CITY OF ALBUQUERQUE

**Planning Department
Transportation Development Services**

Re: 4th and Montano Dental Office
5508 4th St., NW
Traffic Circulation Layout
Engineer's/Architect's Stamp dated 6-15-15 (F14-D055)

**RE: 4TH AND MONTANO DENTAL OFFICE
5508 4TH ST., NW
TRAFFIC CIRCULATION LAYOUT (F14-D055)**

ENGINEER'S SEAL 4TH ST AND MONTANO DENTAL OFFICE	DRAWN BY DY
	TRAFFIC CIRCULATION LAYOUT	DATE 5/22/15
TIERRA WEST, LLC 5571 MIDWAY PARK PLACE NE ALBUQUERQUE, NM 87109 (505) 858-3100 www.tierrowestllc.com		2014099-TCL
RONALD R. BOHANNAN P.E. #7868		SHEET # C1
		JOB # 2014099

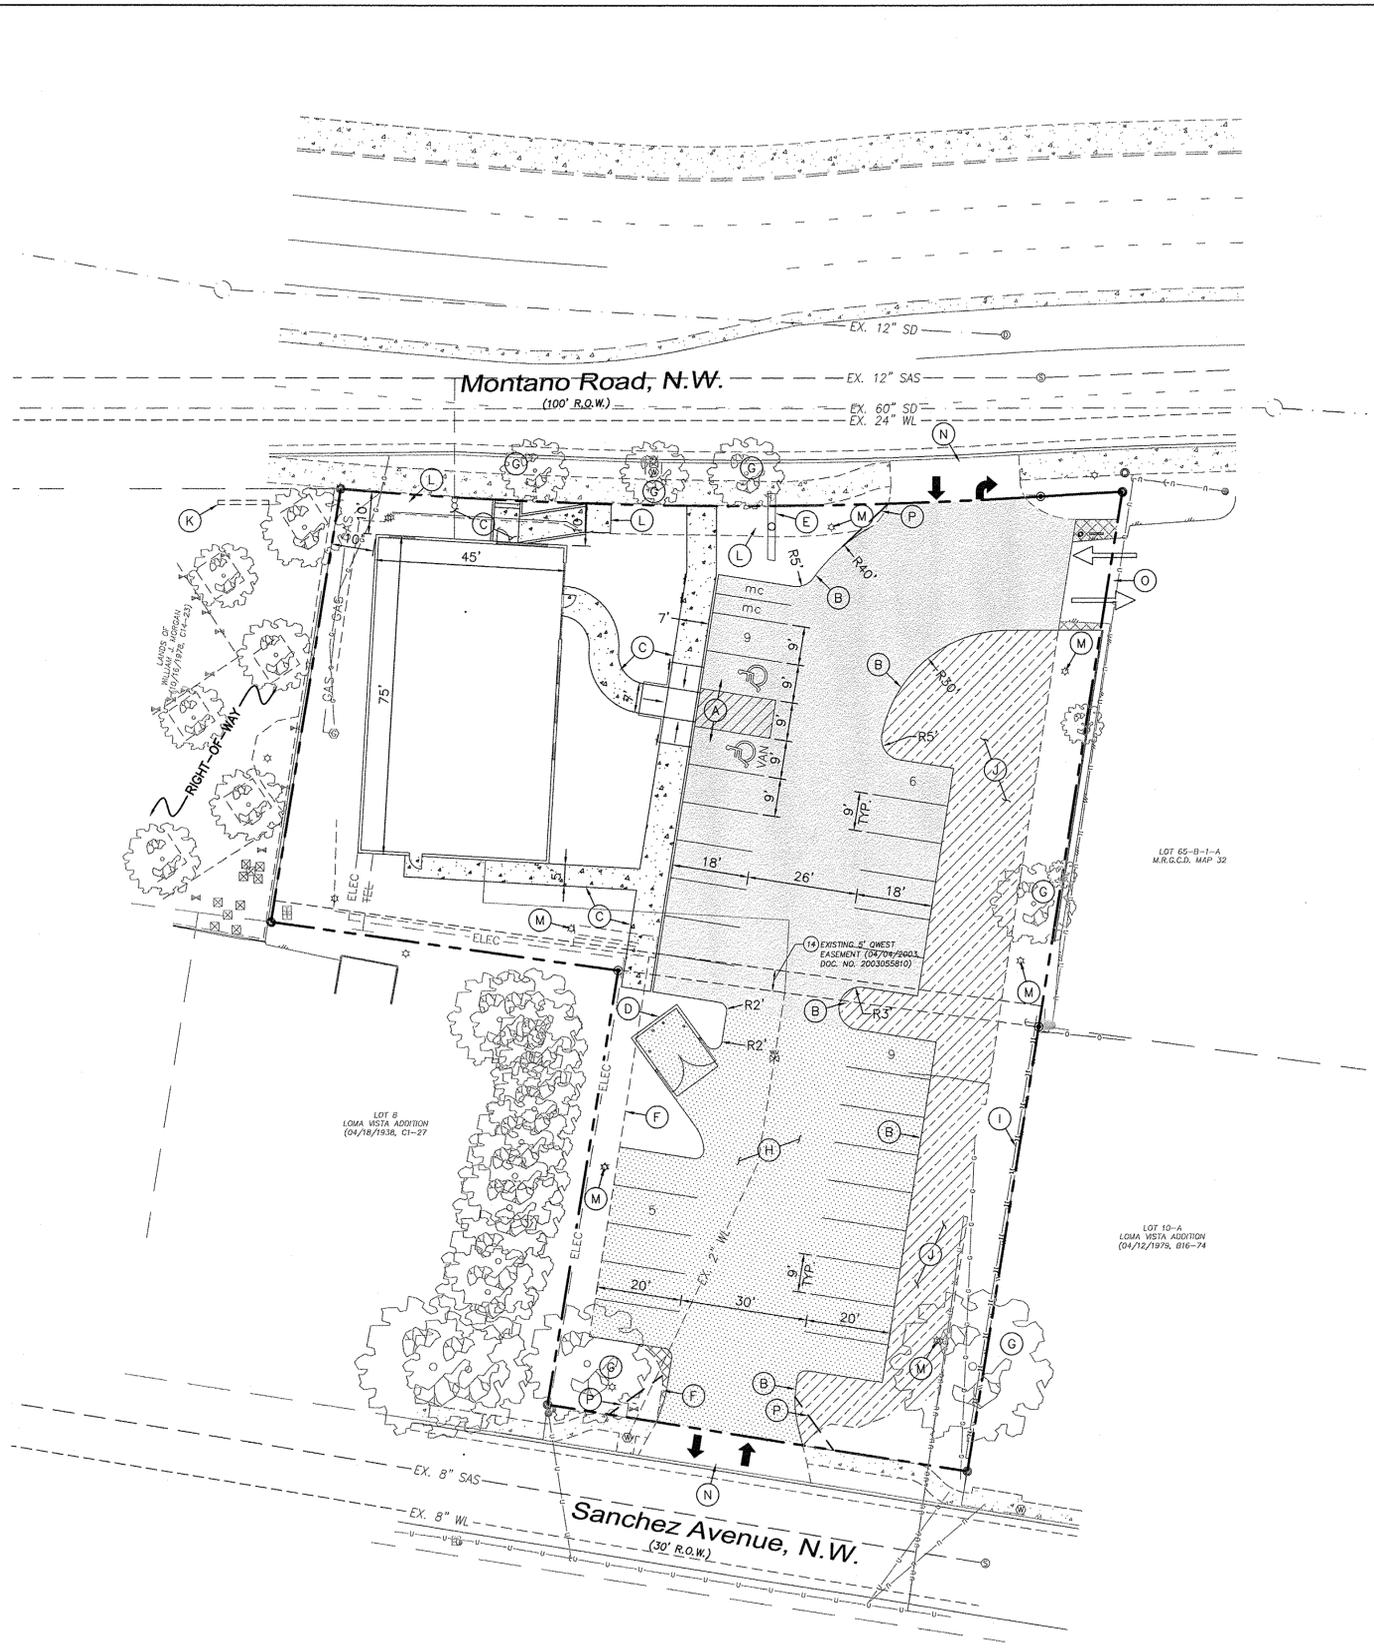
1. Clarify the extents of the current phase.
Response: The proposed building and all associated parking facilities will be constructed in a single phase after the existing structures are demolished. Portions of the existing pavement not in conflict with the proposed parking facility will remain as shown on sheet C1.

3. Identify and dimension the existing right of way width, medians, sidewalks and curb cuts on Montano Rd., Sanchez Ave. and into the parcel to the east of the proposed building.

4. Please show a detail with dimensions and slope of the ADA pedestrian walkway transition from the ADA parking spaces.
Response: We added Detail "A" on sheet C1 to include the dimensions and slopes of the ADA pedestrian walkway transitions from the ADA parking spaces.

5. The ADA van accessible sign must have the required language per 66-7- 352.4C NMSA 1978 "Violators Are Subject to a Fine and/or Towing." Please show a detail of this signage.

7. Show all drive aisle widths and radii.

8. Design delivery vehicle route needs to be shown

10. Please add the following note to the clear sight triangle: "Landscaping and signage will not interfere with clear sight requirements. Therefore, signs, walls, trees, and shrubbery between 3 and 8 feet tall (as measured from the gutter pan) will not be acceptable in this area."

**ACCESSIBLE PARKING LOT SIGN**

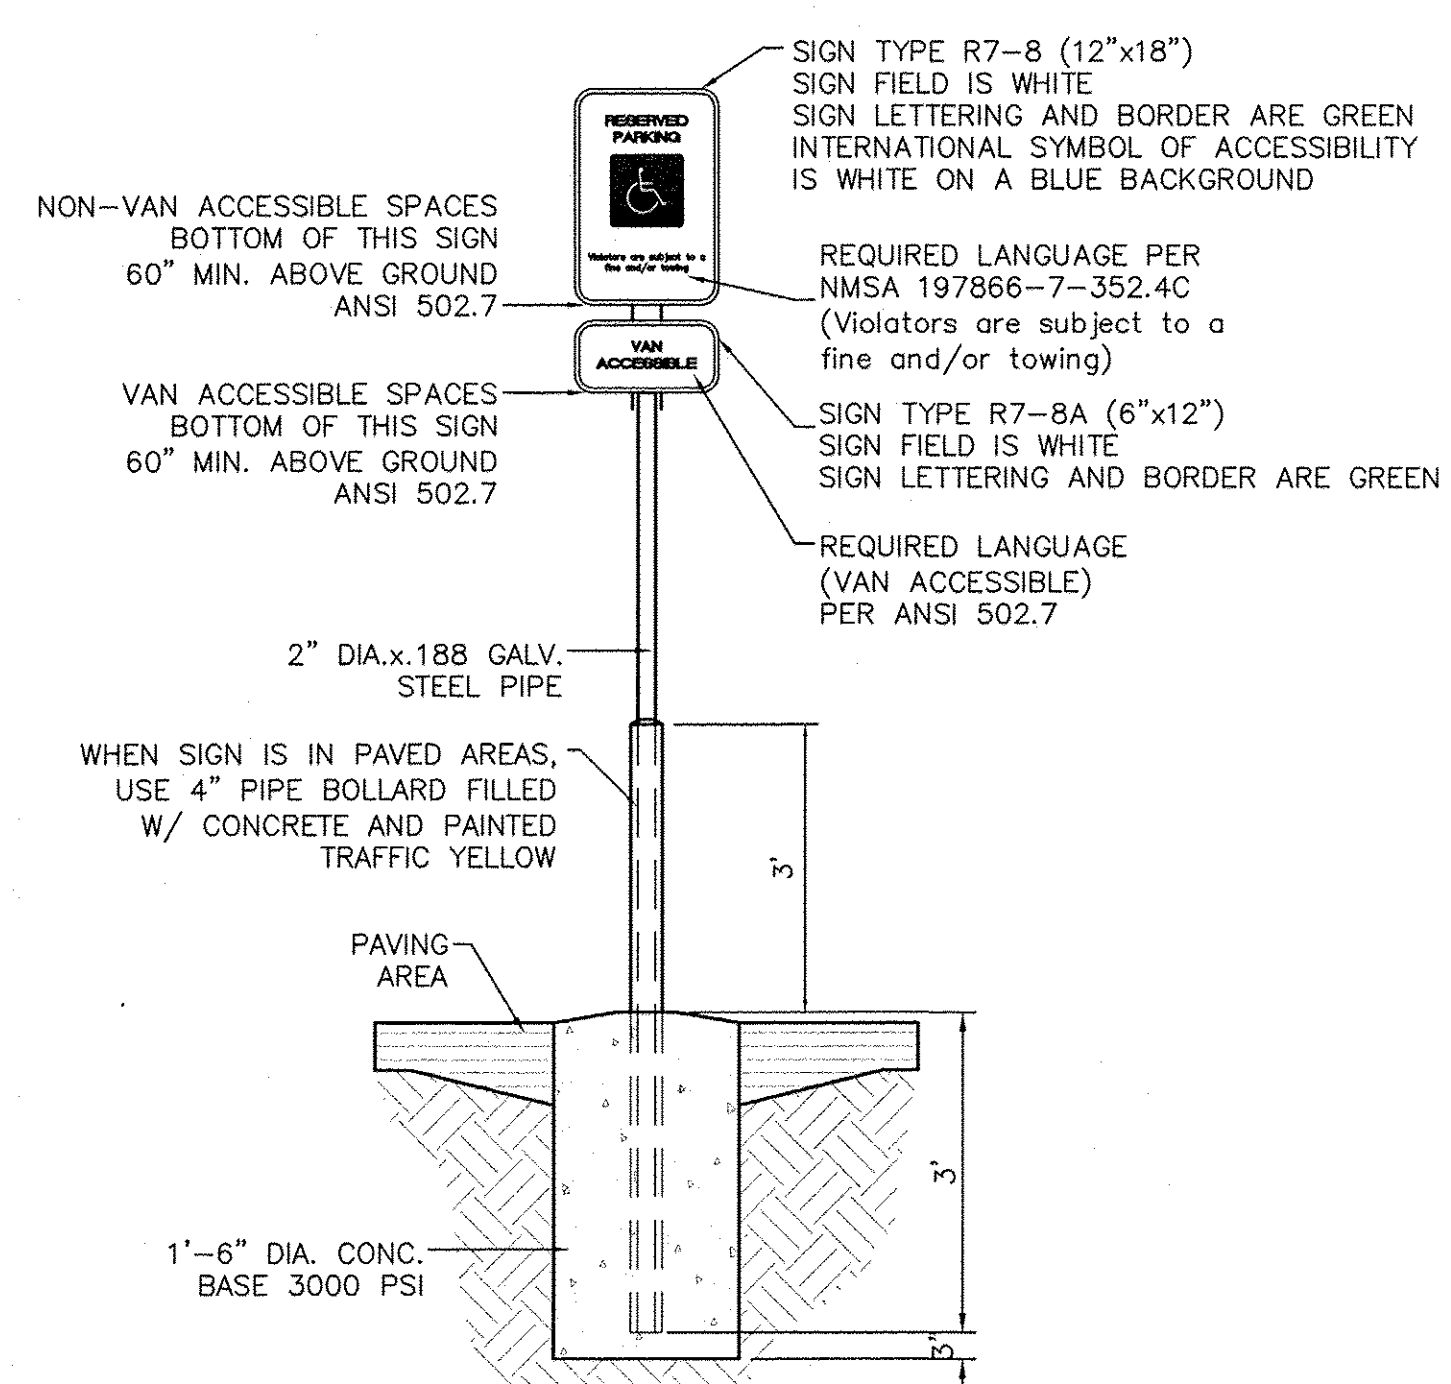
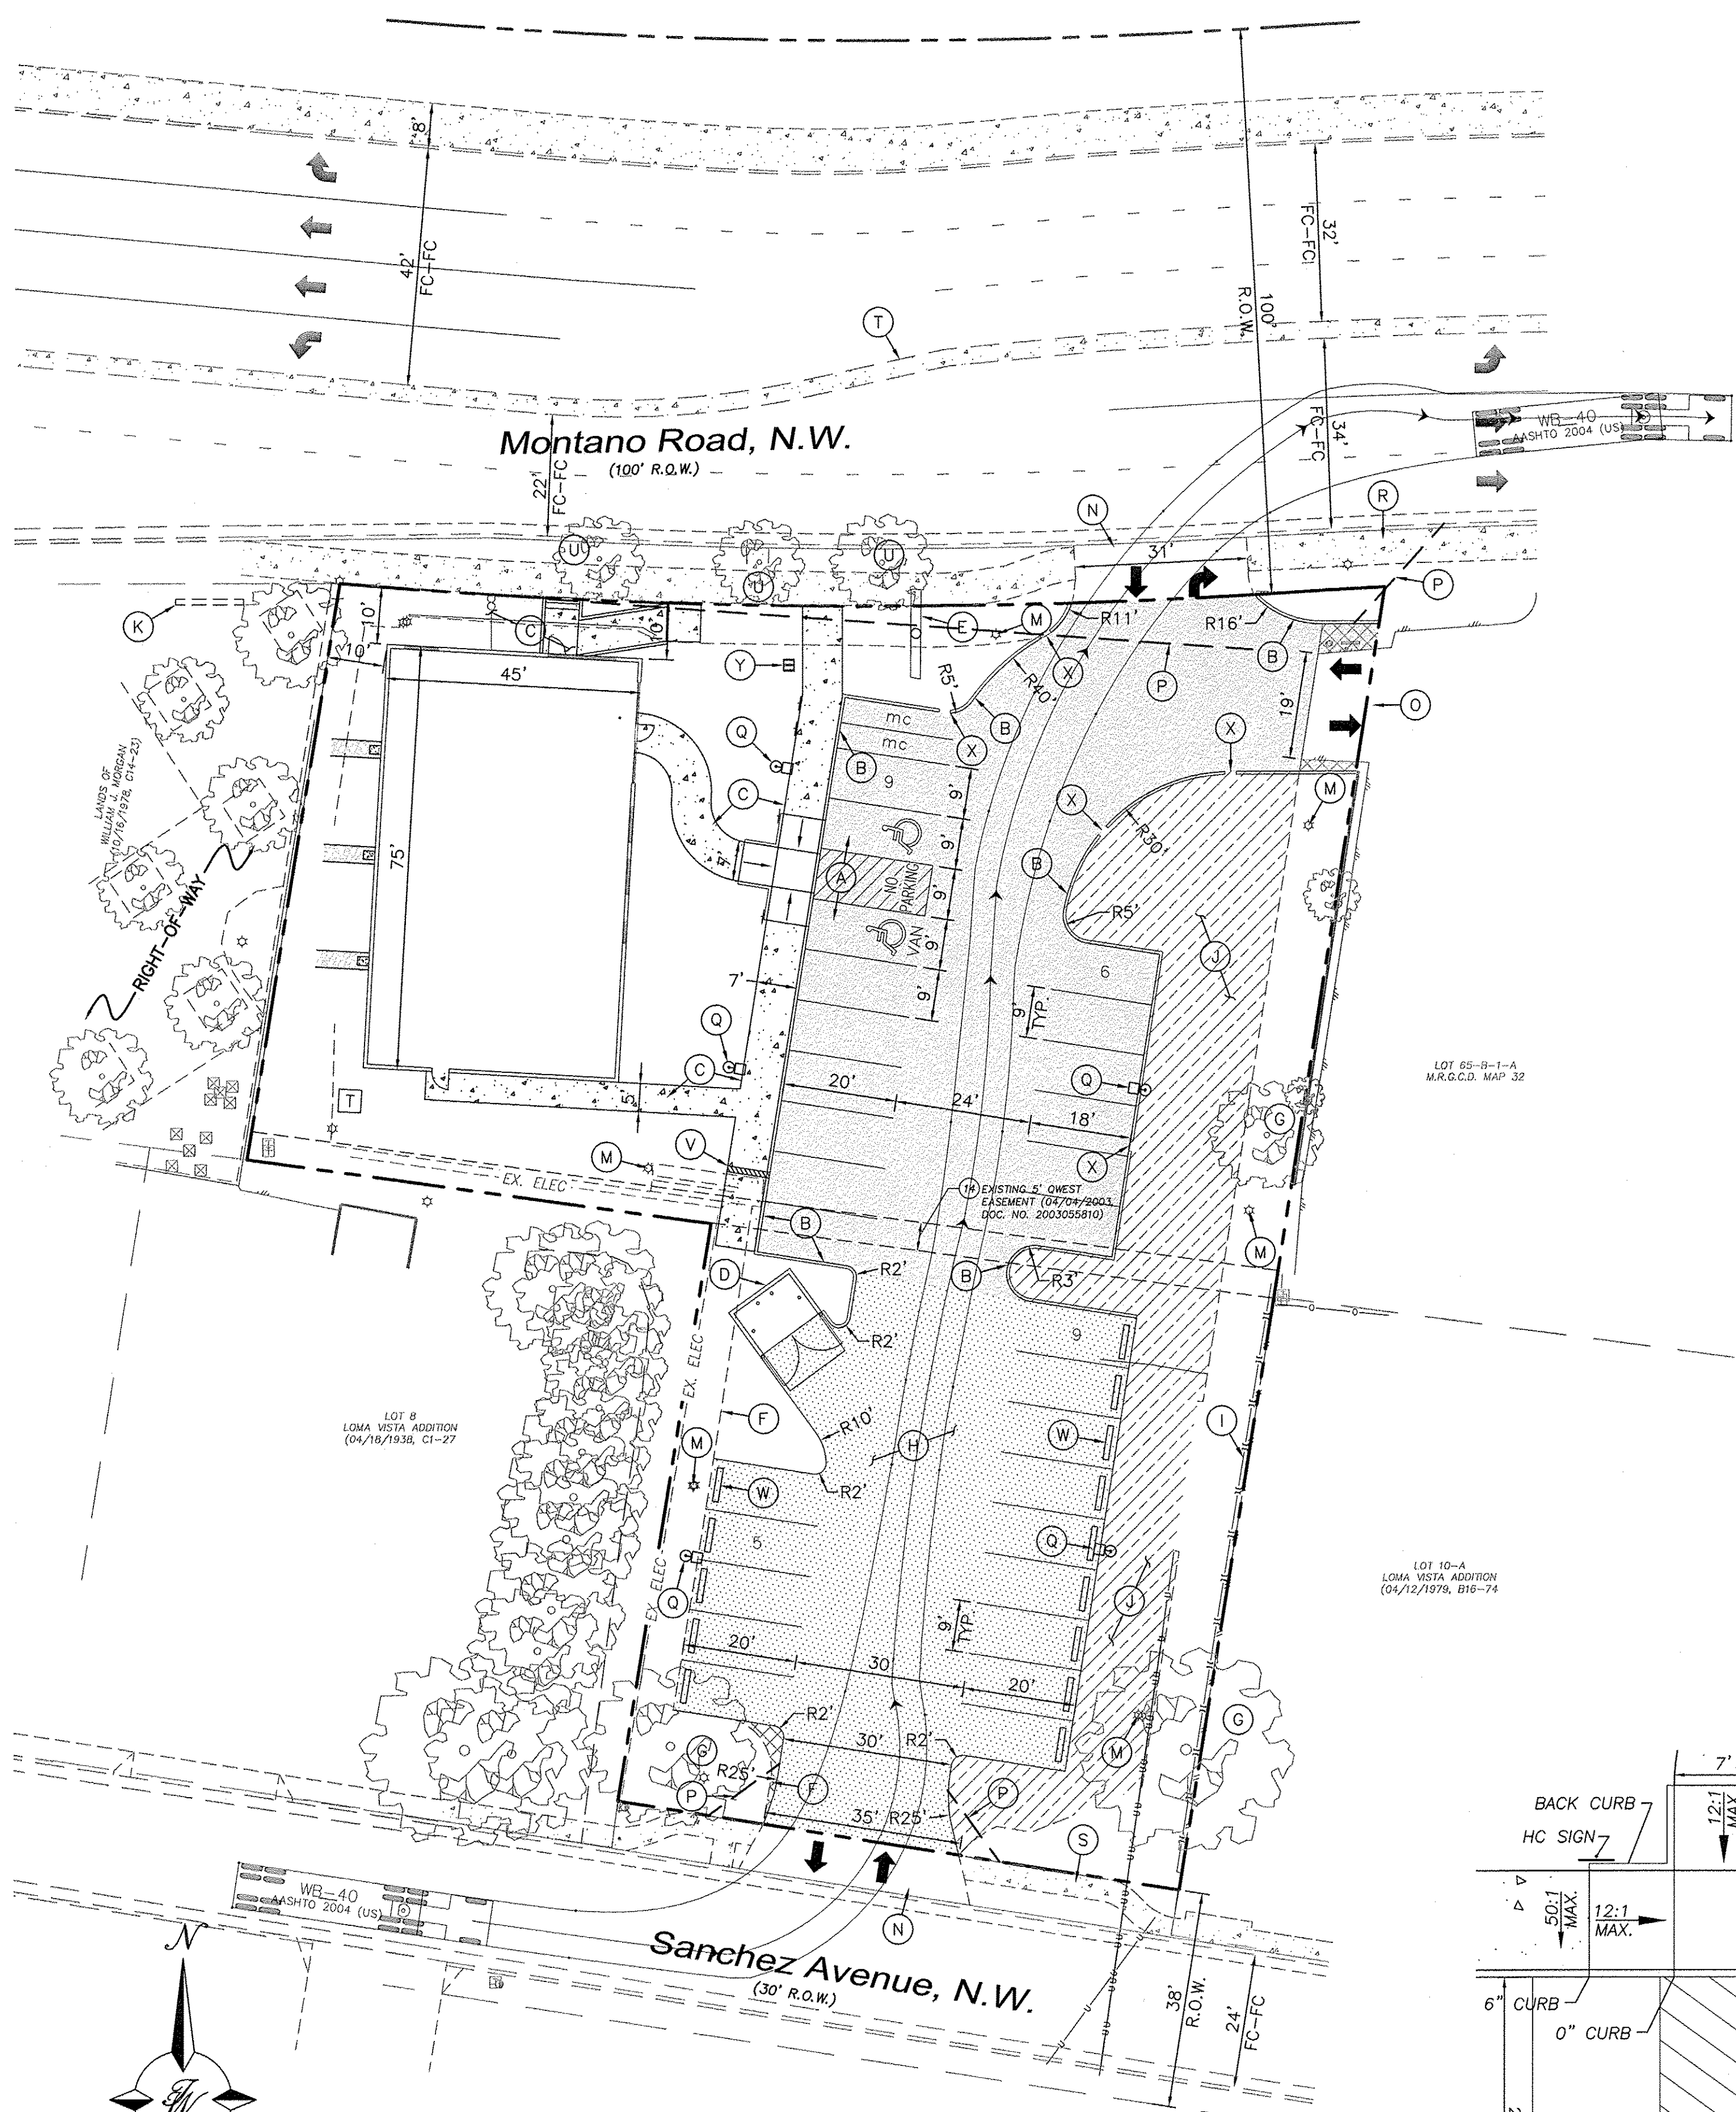
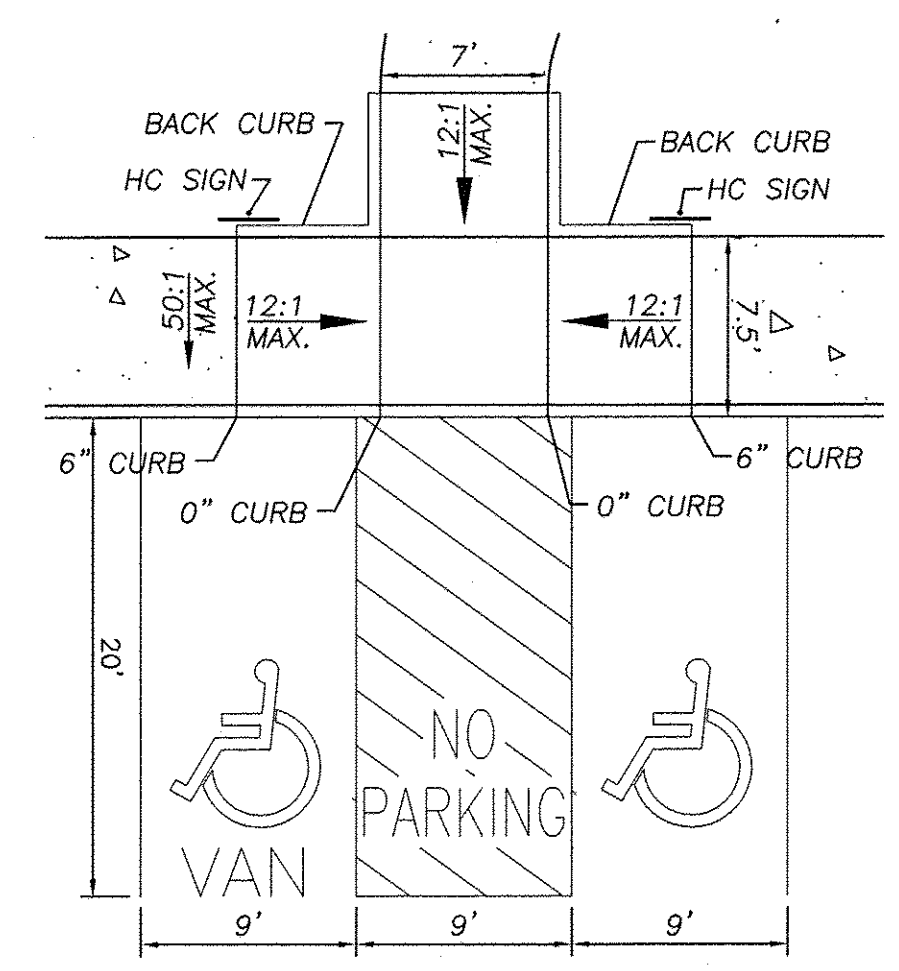
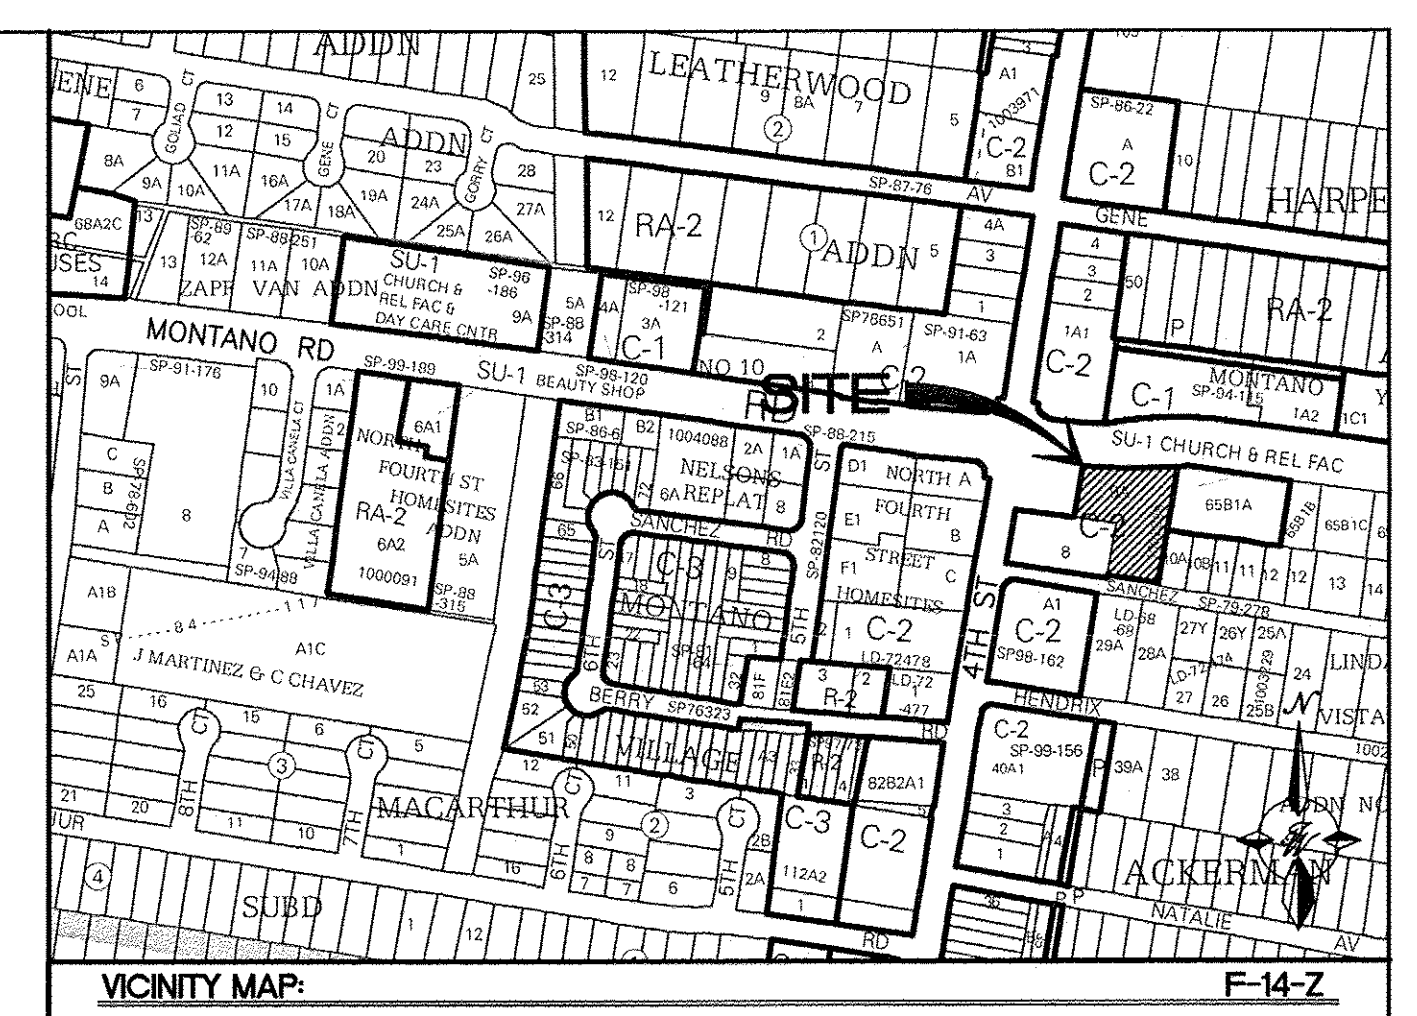
parking space so as to be close to where an adjacent vehicle's rear tire would be placed. (66-1-4.1.B NMSA 1978).

Response: We updated the "Accessible Parking Lot Sign" detail on sheet C1 to include the language referenced above.
6. The ADA access aisle shall have the words "NO PARKNG" in capital letters, each of which shall be at least one foot high and at least two inches wide, placed at the rear of the

Response: We added Detail "A" on sheet C1 to include the "NO PARKING" pavement marking as described above.

Response: We annotated all the drive aisle width dimensions and radii on sheet C1.

Response: We added the delivery vehicle route for a WB-40 design vehicle onto sheet C1.

Response: We added the note referenced above onto sheet C1 as Keyed Note P.
